Ribble Valley Borough Council
Council Offices
Church Walk,
Clitheroe
Lancashire
BB7 2RA

Phone: 0300 123 6780
Email: developeras@lancashire.gov.uk
Your ref: 3/2025/0277
Our ref: 3/2025/0277/HDC/KW
Date: 13 June 2025

Location: 4 Longridge Road Hurst Green BB7 9QP
Proposal: Proposed change of use of annex to holiday let.
Grid Ref: 368440 437882

Frank Taylor Annex

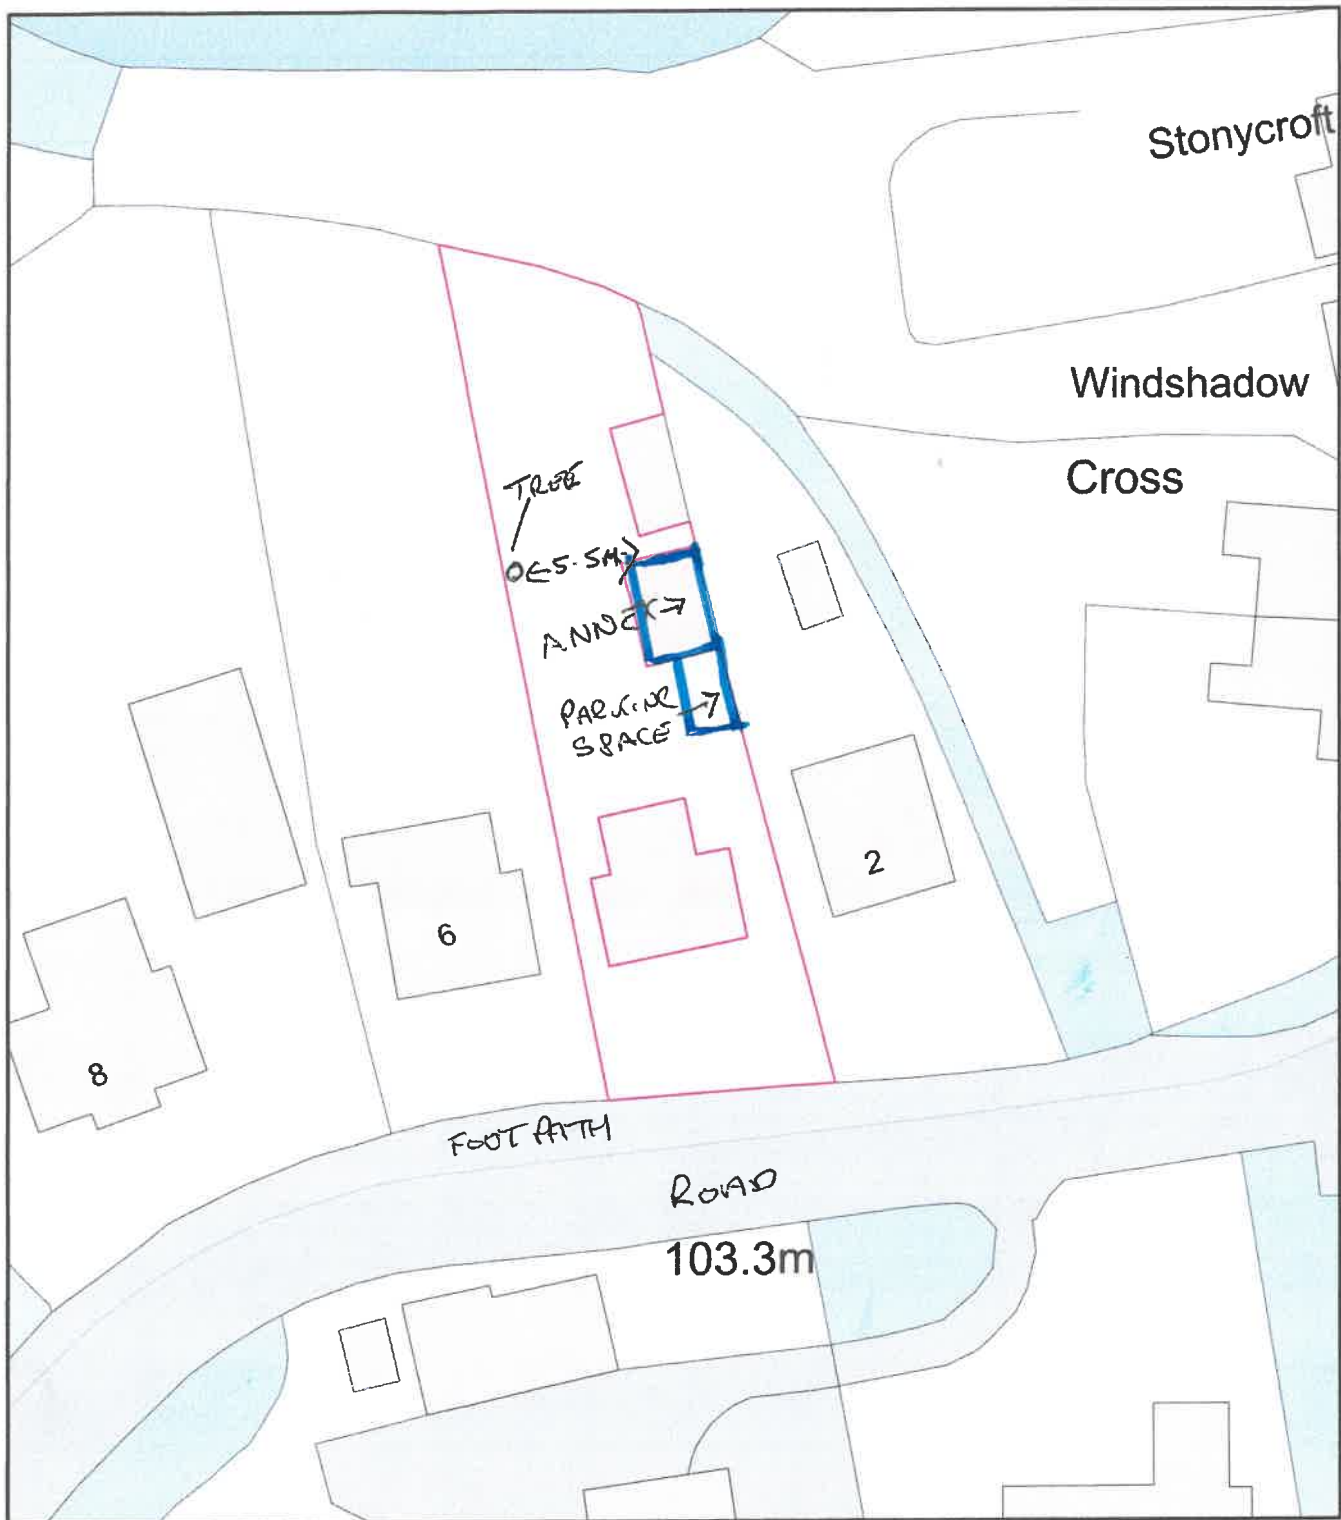
The LHA understand that the existing dwelling has 3 bedrooms and as such the dwelling complies with the LHAs parking standards as defined in the Joint Lancashire Structure Plan. An additional parking space as shown on the site plan has been provided for the proposed holiday let, which will provide acceptable off-street parking provisions for the proposal. Therefore, the LHA have no objection to the proposal.

1. No use hereby permitted shall commence until the car parking area has been surfaced or paved in accordance with a scheme to be approved by the Local Planning Authority and the car parking spaces and manoeuvring areas marked out in accordance with the approved plan. The car parking area shall thereafter be kept free of obstruction and available for the parking cars at all times. **Reason:** To allow for the effective use of the parking areas.
